12th June 2025 MPS Ref: 102/2025

SUBMISSION IN RESPONSE TO SSD-82395459 PROPOSED RESIDENTIAL DEVELOPMENT 3A, 3B, 5A & 7 BURGOYNE STREET AND 4 BURGOYNE LANE, GORDON

This submission has been prepared on behalf of the owners of the adjoining property located at 9 Burgoyne Street, Gordon.

ALLOWED VOLUME - JUNE 21st 9:00 AM

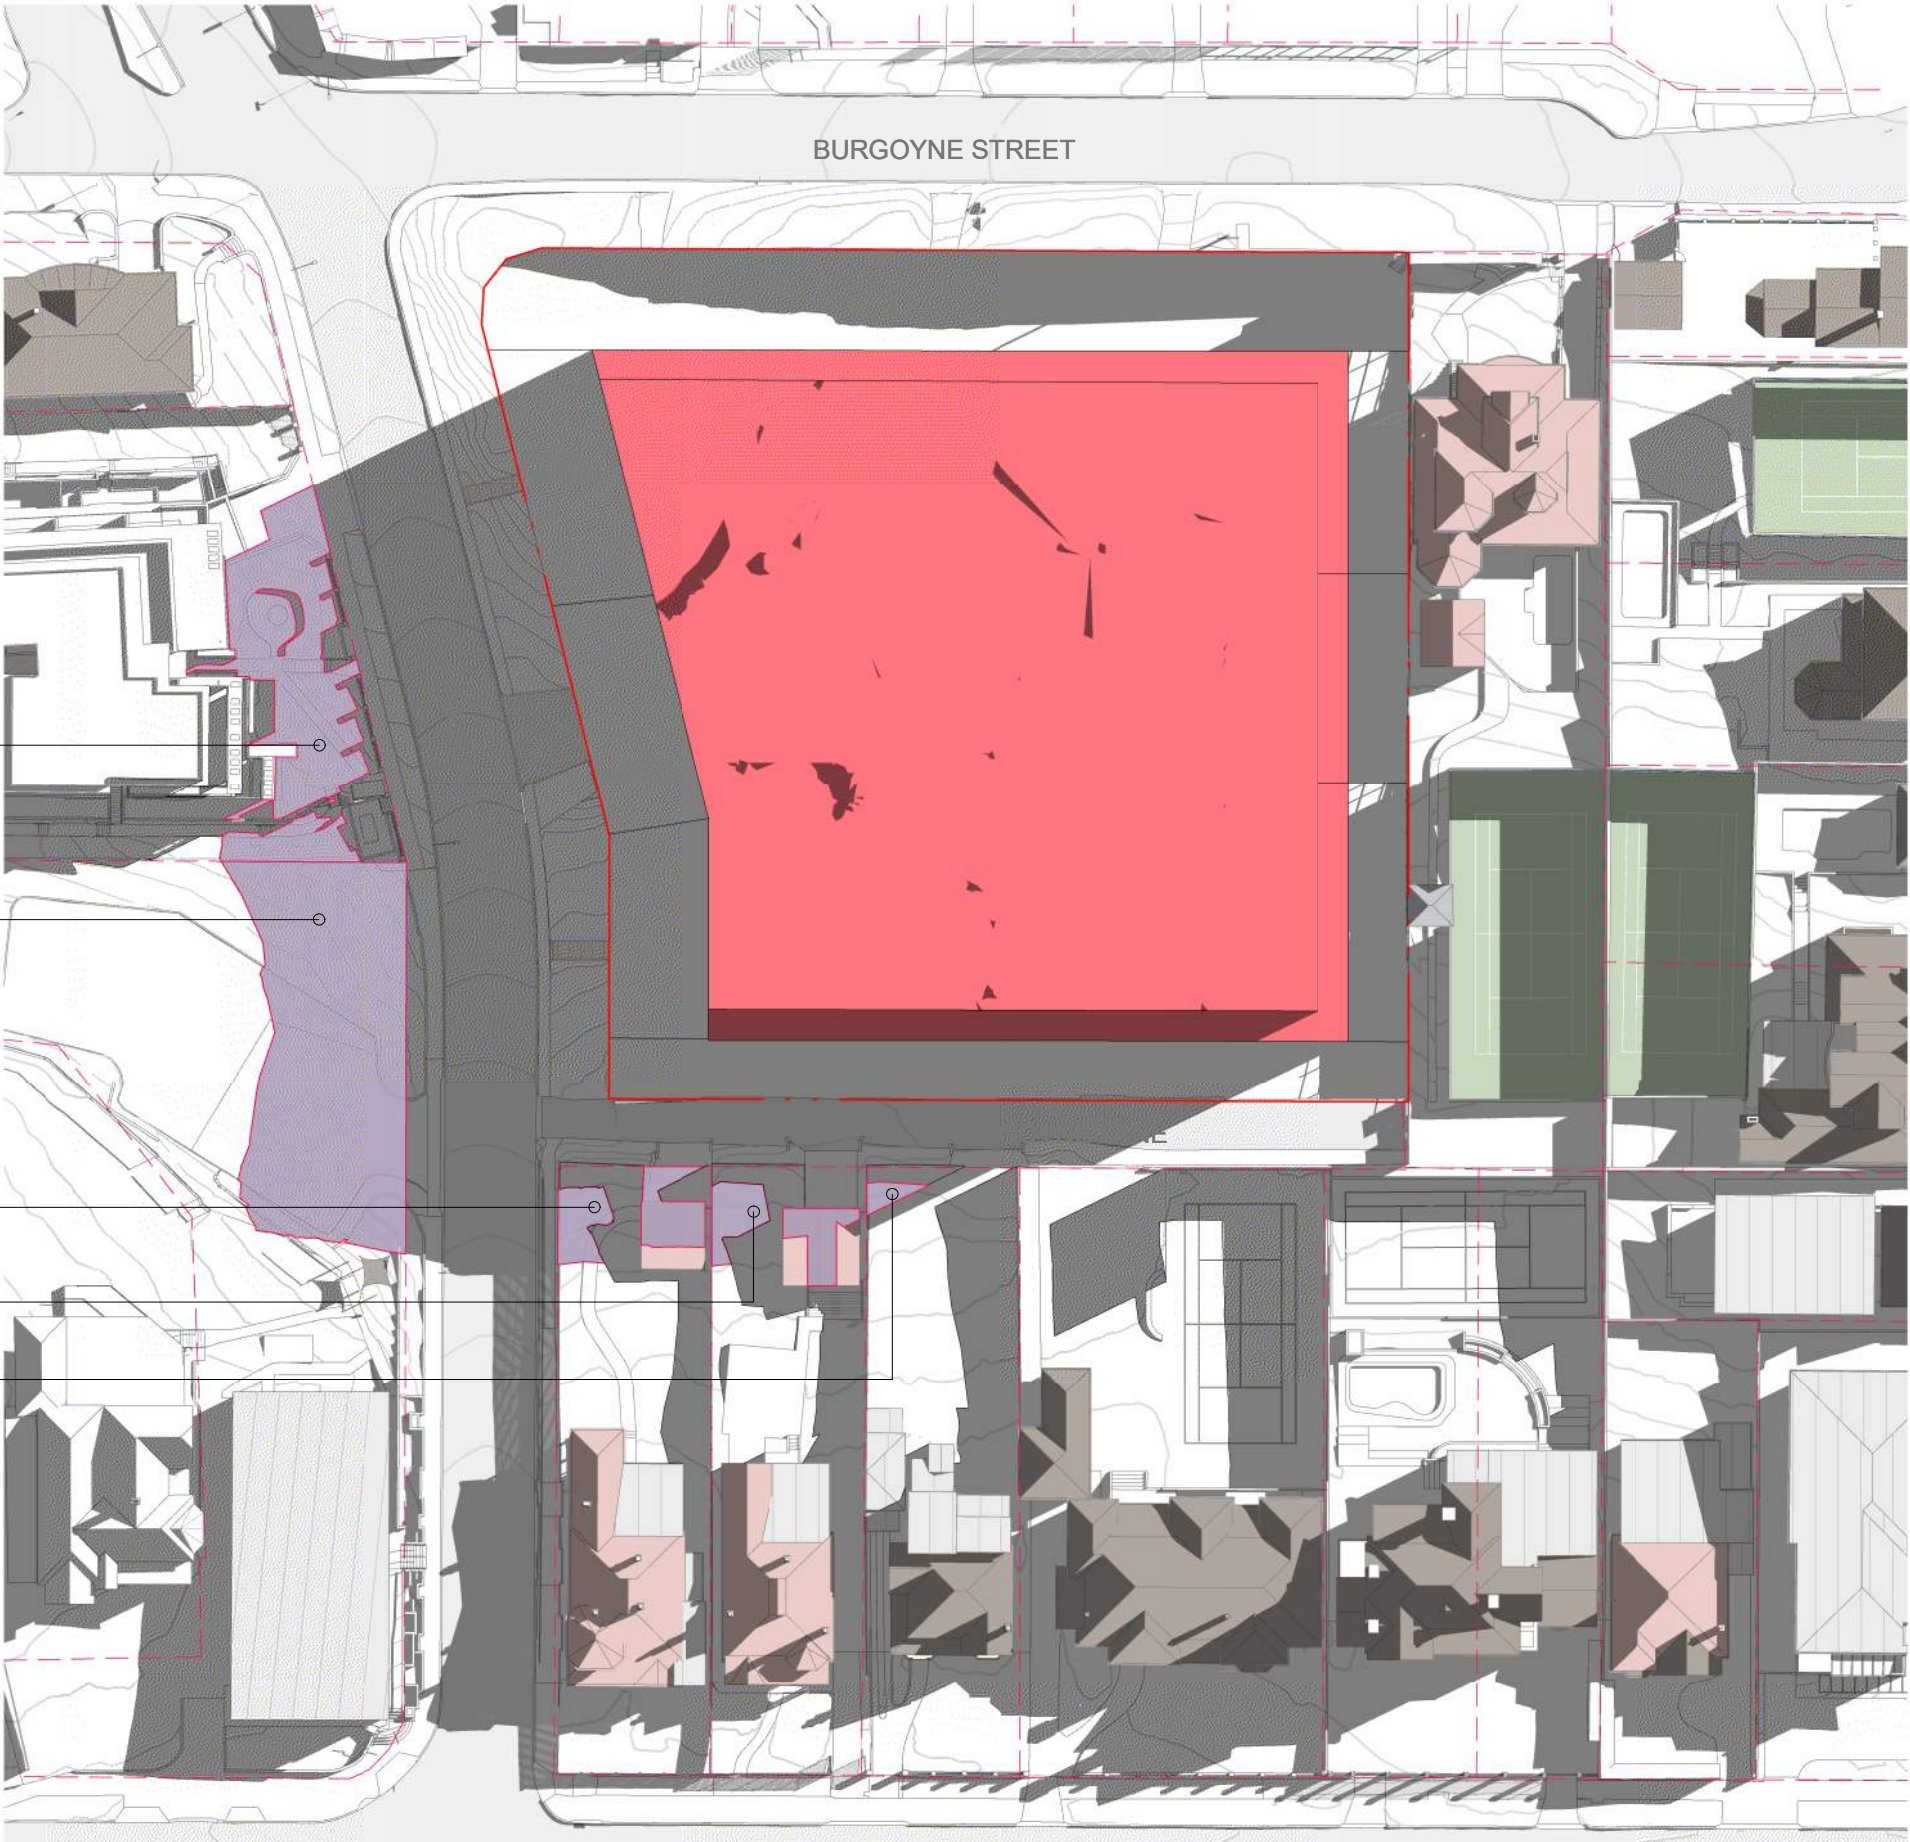
It is our opinion that as a result of these non-compliances there will be significant unreasonable impacts upon the amenity and heritage value of 9 Burgoyne Street. The proposal will also result in unreasonable streetscape impacts as a result of the significant disparity in height between development upon the development site and 9 Burgoyne Street and the failure to provide an appropriate transition between the proposal and 9 Burgoyne Street. The proposed disparity in height of building and the reasoning behind why compliant setback are critical is best demonstrated by the Applicant's View from the Sun Diagrams and in particular the 9am diagram reproduced below:
